**COMMENTS ON
DIVISION 5.2 AND EPBC ACT APPROVAL
MODIFICATION ASSESSMENT REPORT
ON THE
ADAMS ROAD INTERSECTION
WITH
THE NORTHERN ROAD
December 2018**

Figure 1-1 | Overview of proposed changes to Stage 6 of the project

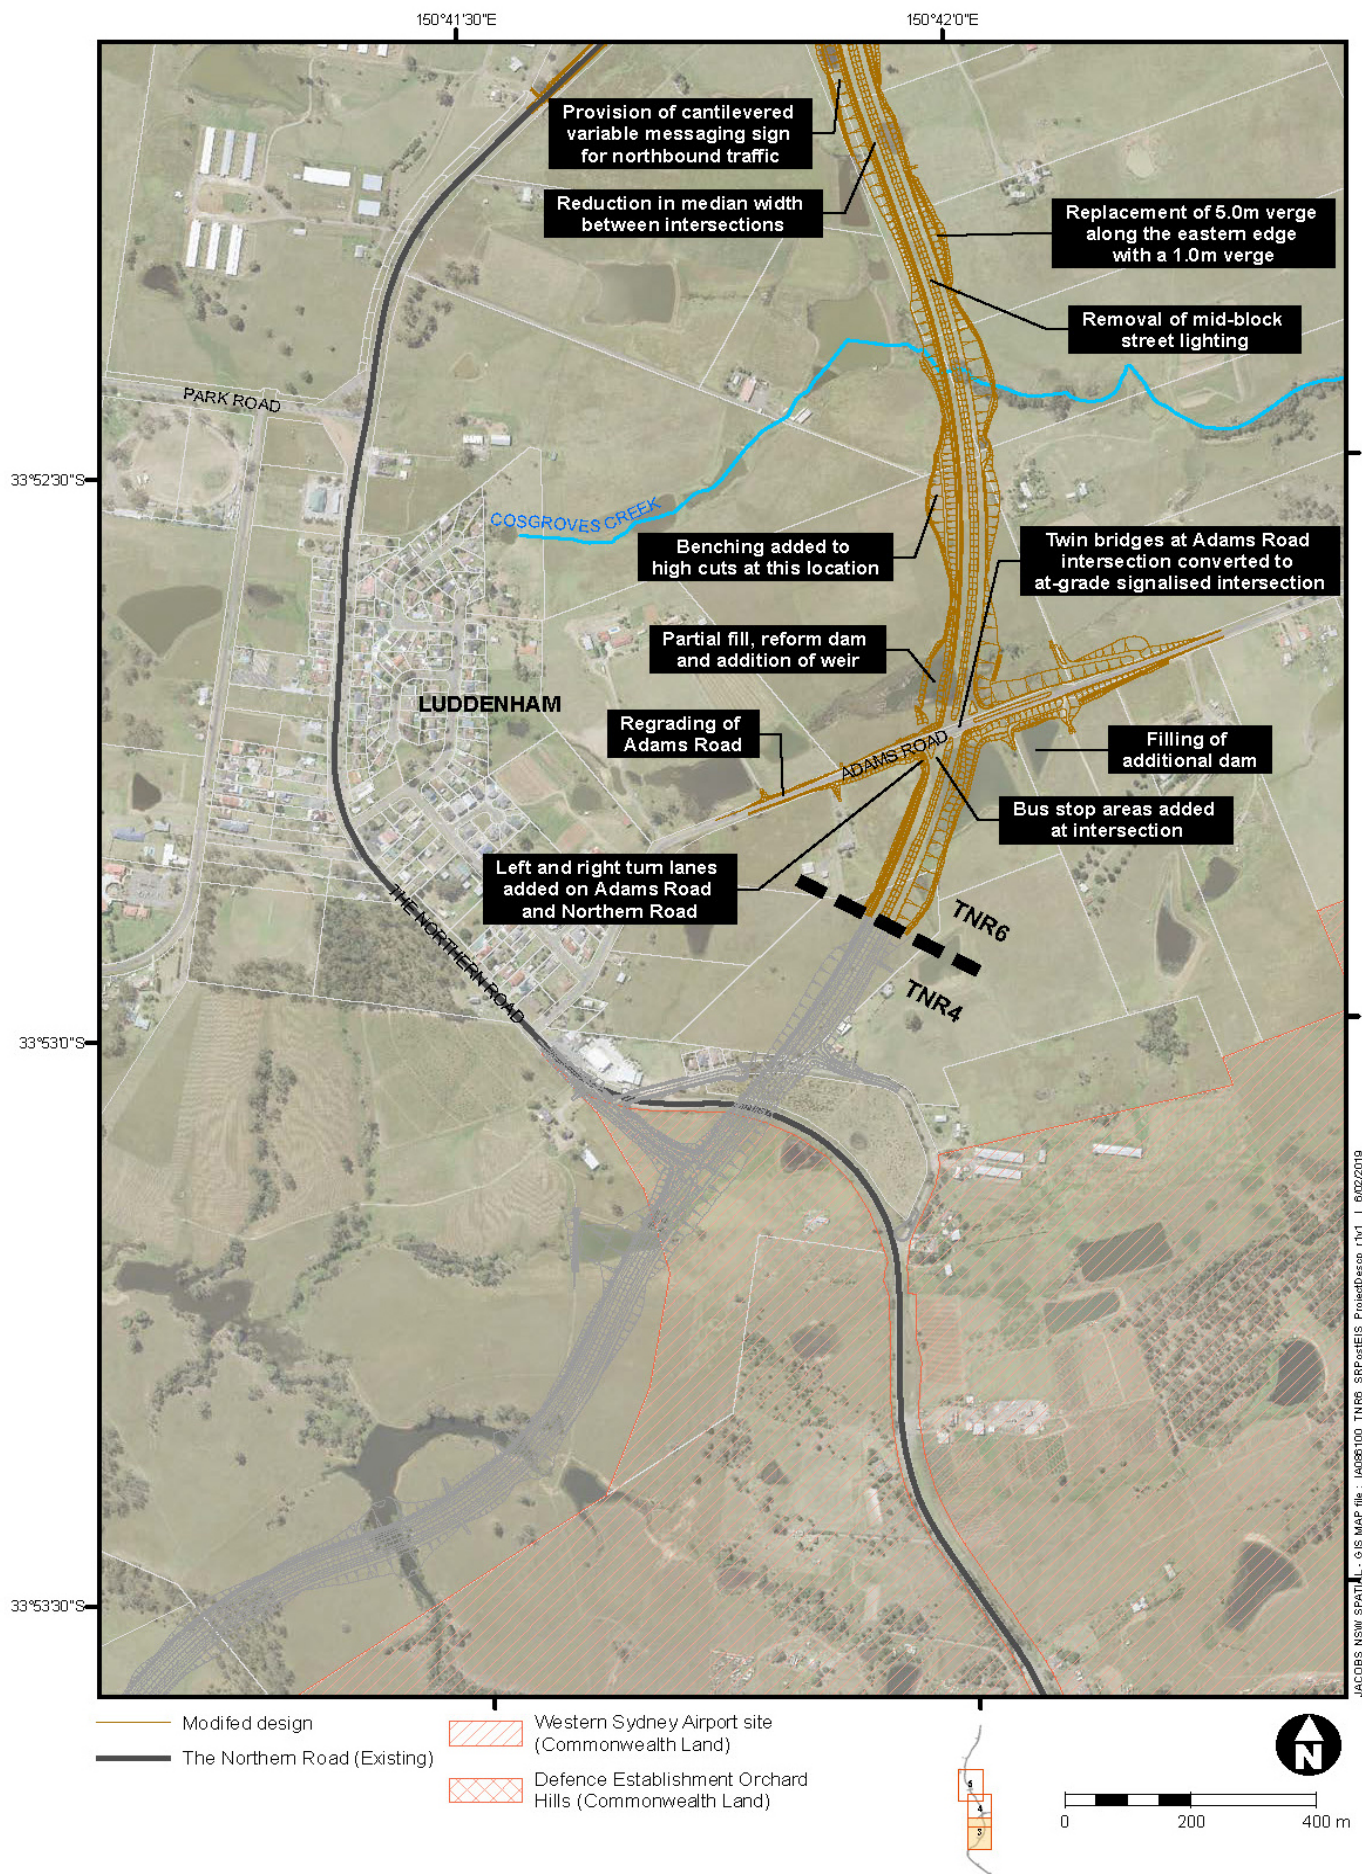
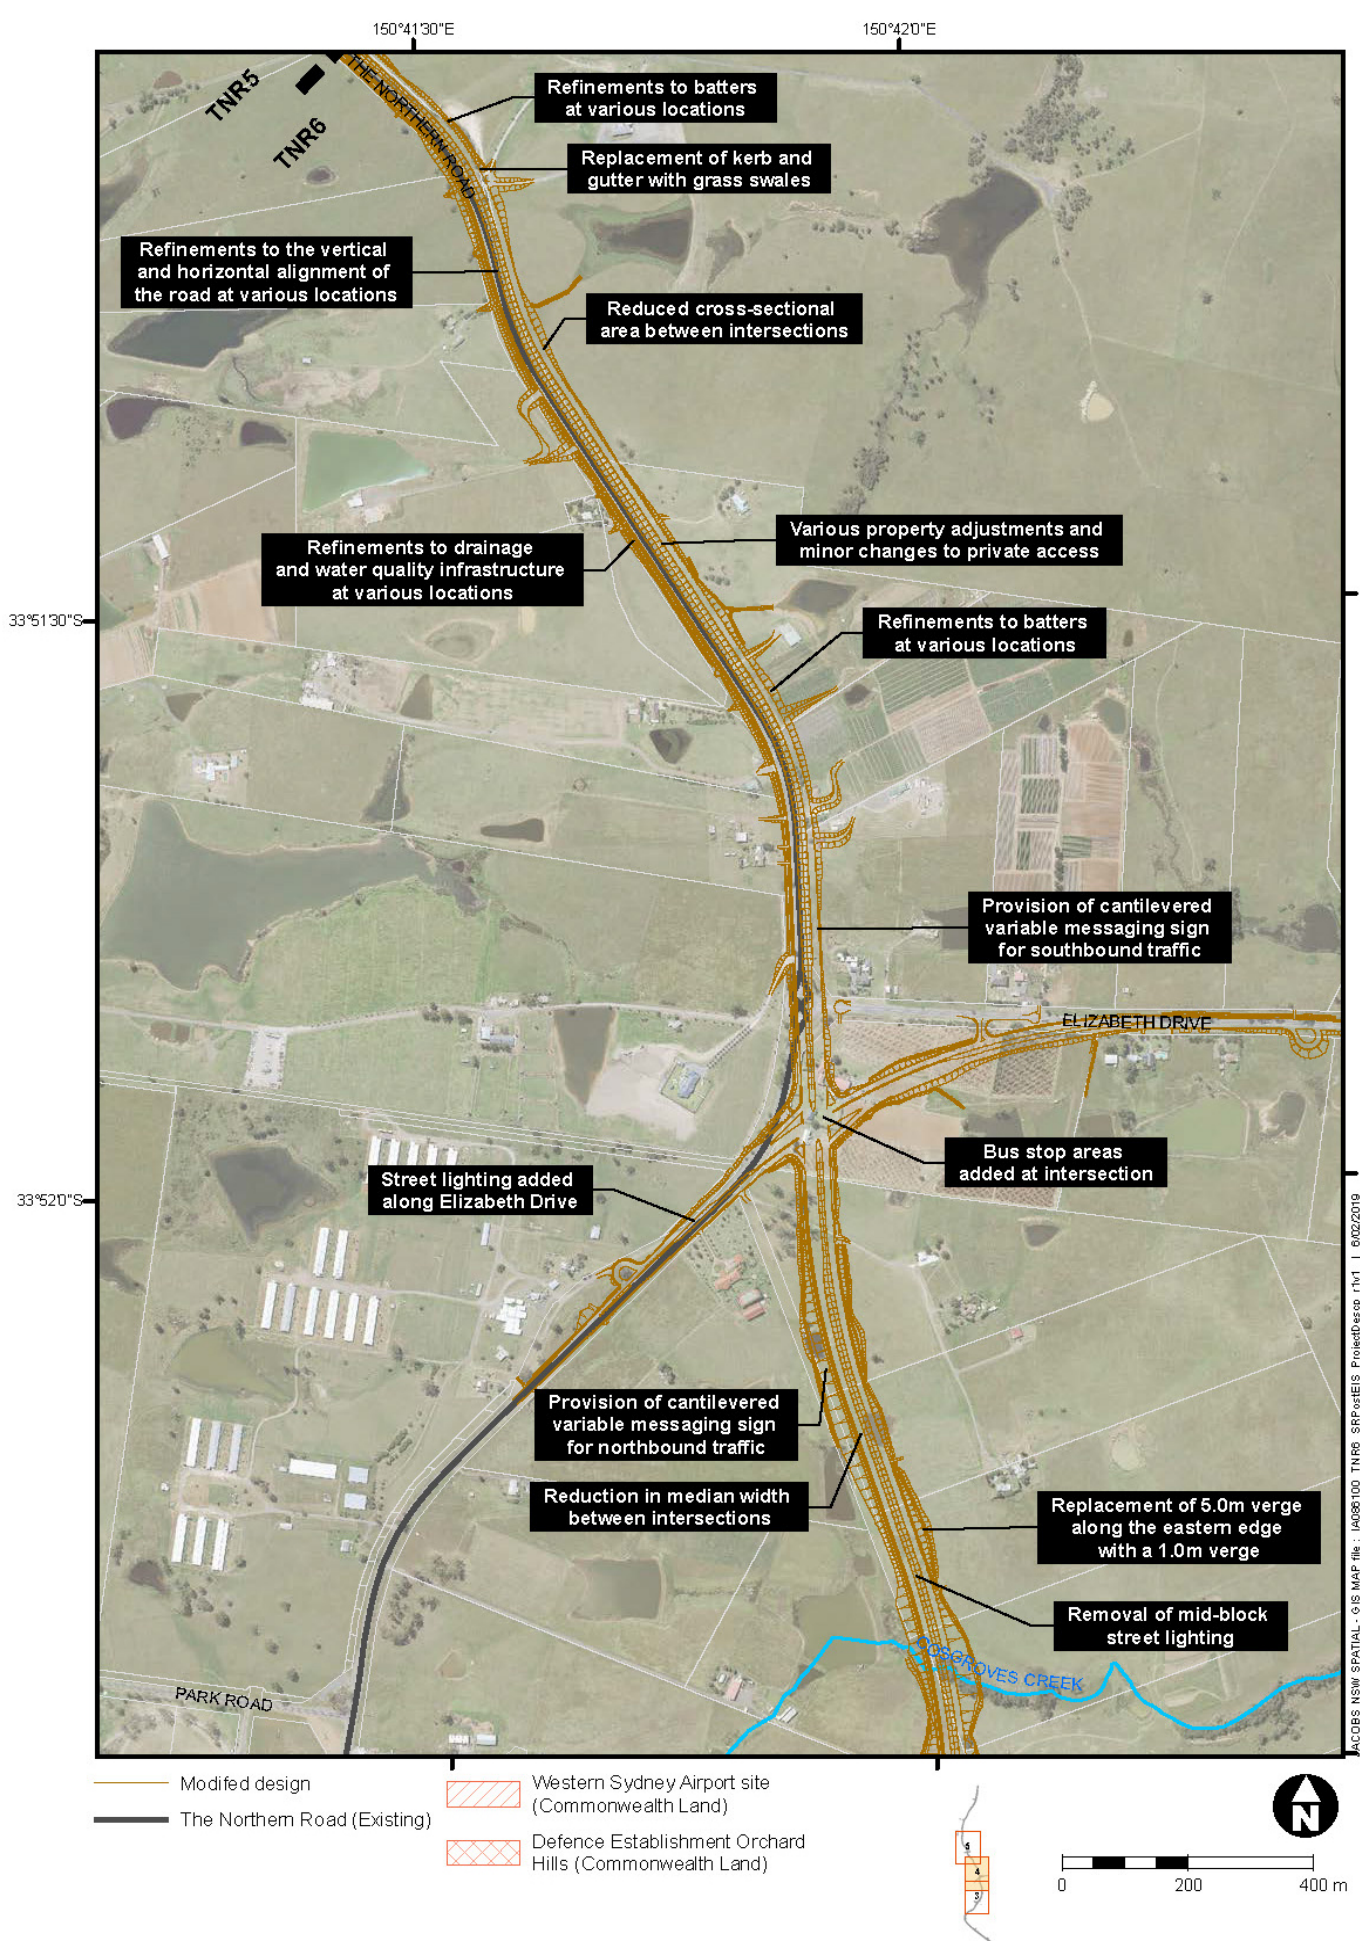
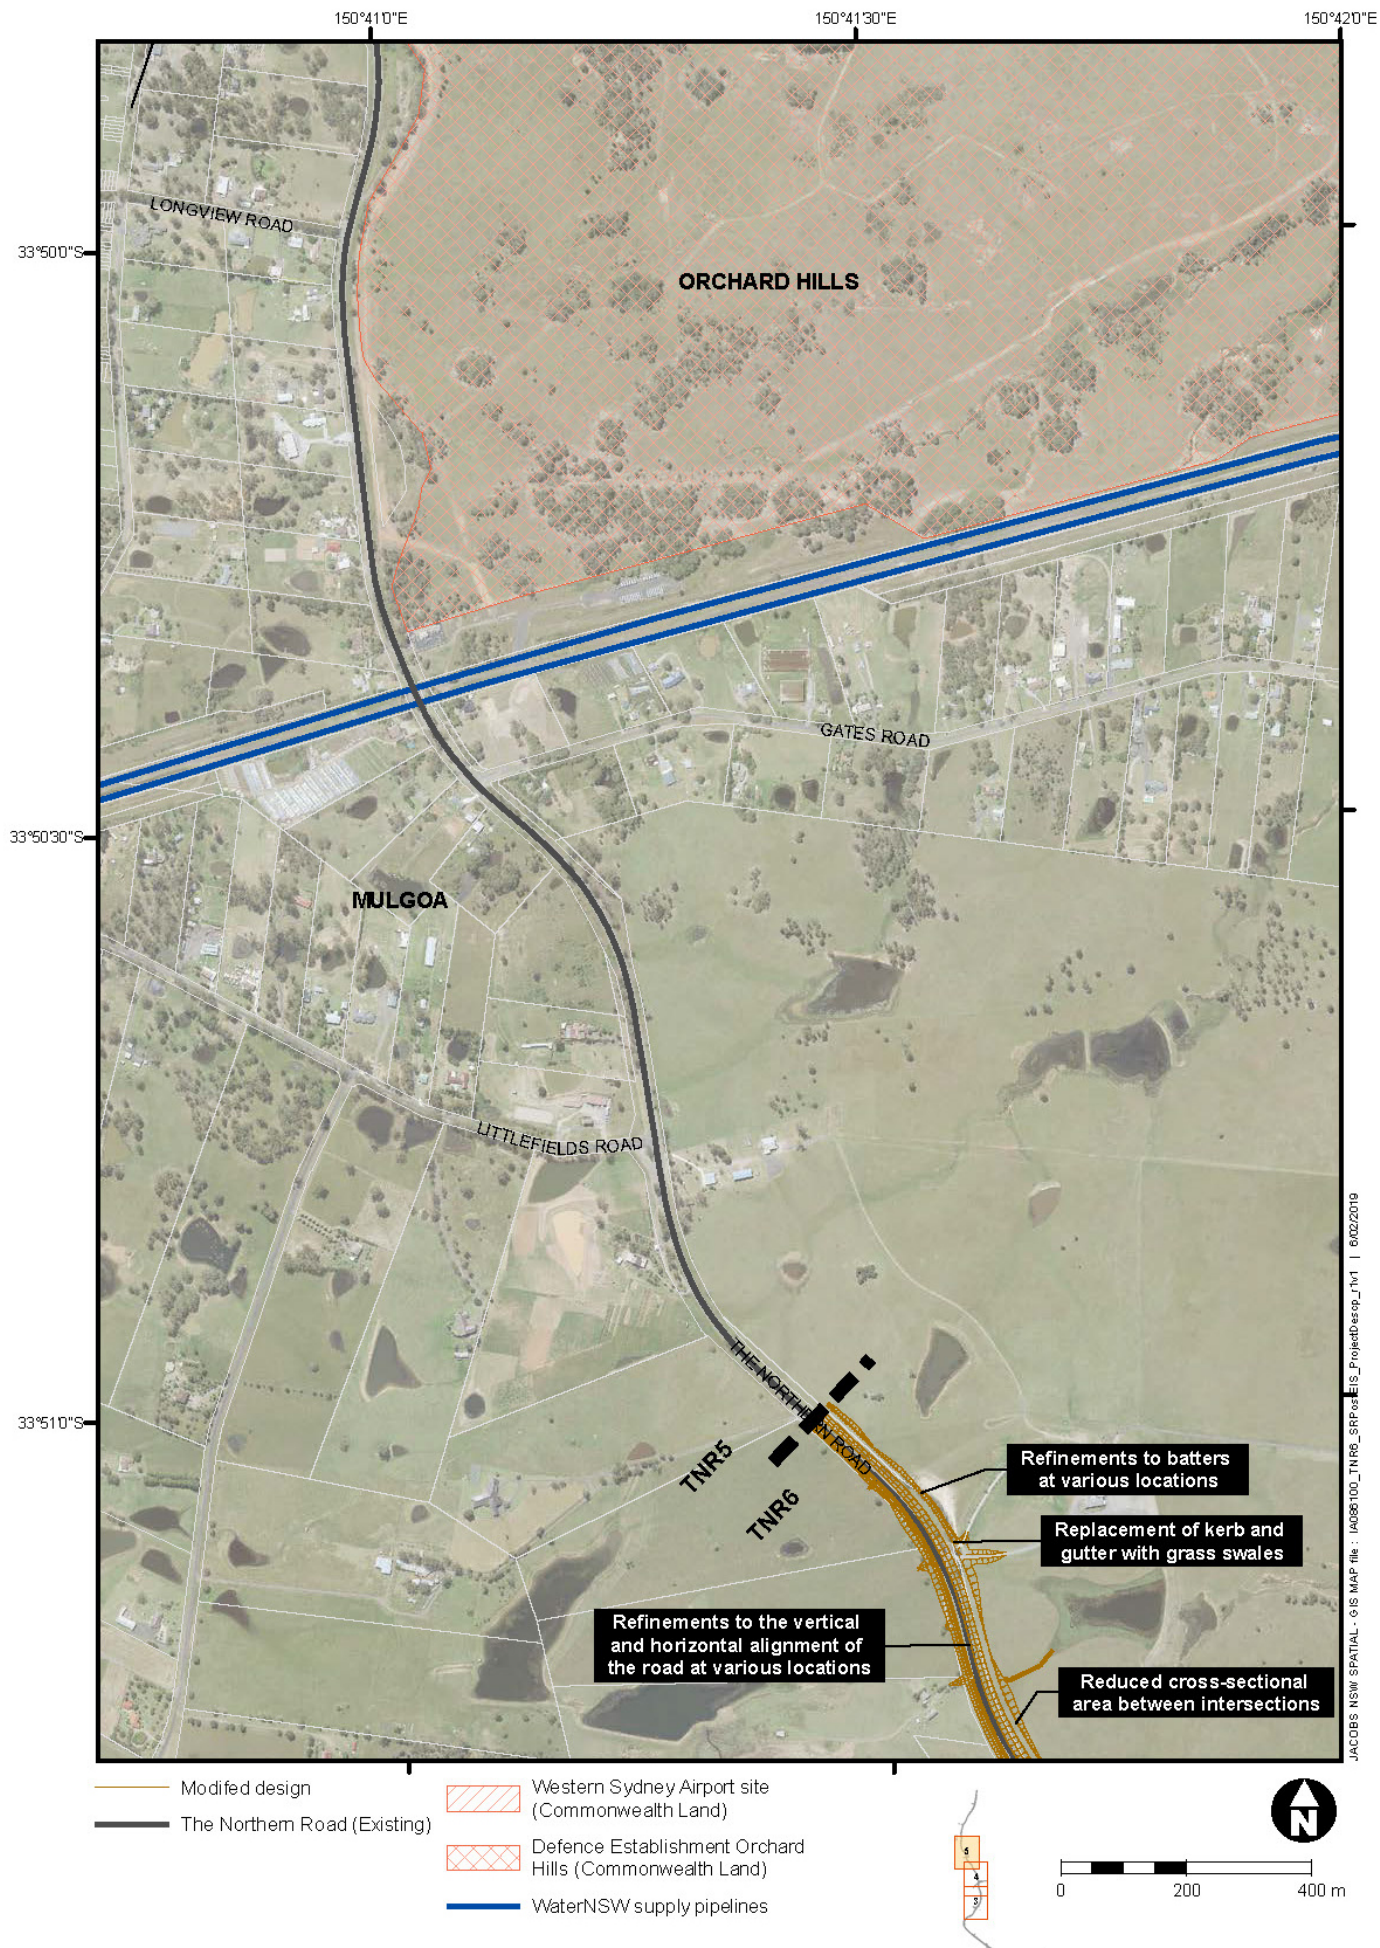
“...An increase in traffic volumes along Adams Road (to about 700 vehicles per hour), which would exceed the Guide to Traffic Generating Developments (Road and Traffic Authority, 2012) guidelines for environmental capacity limit of a local road (300 vehicles per hour). Measures to mitigate this increase in forecast traffic volumes on Adams Road would be developed in consultation with the local Council.”

The Consultation Report states there will be relatively low existing and forecast traffic; yet this report shows the traffic volumes will increase in excess of the RTA guidelines for a limit of a local road to 1 car every 5 seconds (700 cars per hour).

“The proposed modification would require a larger volume of cut than considered in the SPIR and Final EIS. This is due to the regrading of Adams Road to the west of The Northern Road alignment, which requires excavation to the level of the proposed intersection with The Northern Road.”

Residents of Adams Road from the new intersection alignment to the old Northern Road have not been consulted, advised or informed of the effects to their properties of excavation to the level of the proposed intersection.

This new route would increase traffic volumes along Adams Road by up to 700 vehicles per hour in the peak period, to avoid travelling via the intersection of Elizabeth Drive and The Northern Road. This increase is above the environmental capacity limit for a local road of 300 vehicles per hour (RTA Guide to Traffic Generating Developments, 2012). The RTA guideline specifies suitable traffic volumes from a road network hierarchy perspective to meet acceptable environmental (amenity) outcomes for the local area. Potential mitigation measures for this impact are outlined in

As per previous comments, the increase in traffic volume along Adams Road will negatively affect residents in terms of noise, emissions, safe entry and exit from their properties.

Should this modification to Adams Road proceed, mitigation measures for traffic volume, tare weight restrictions, noise, calming and safety needs to be undertaken and completed at the same time as the proposed Adams Road intersection is open to traffic.
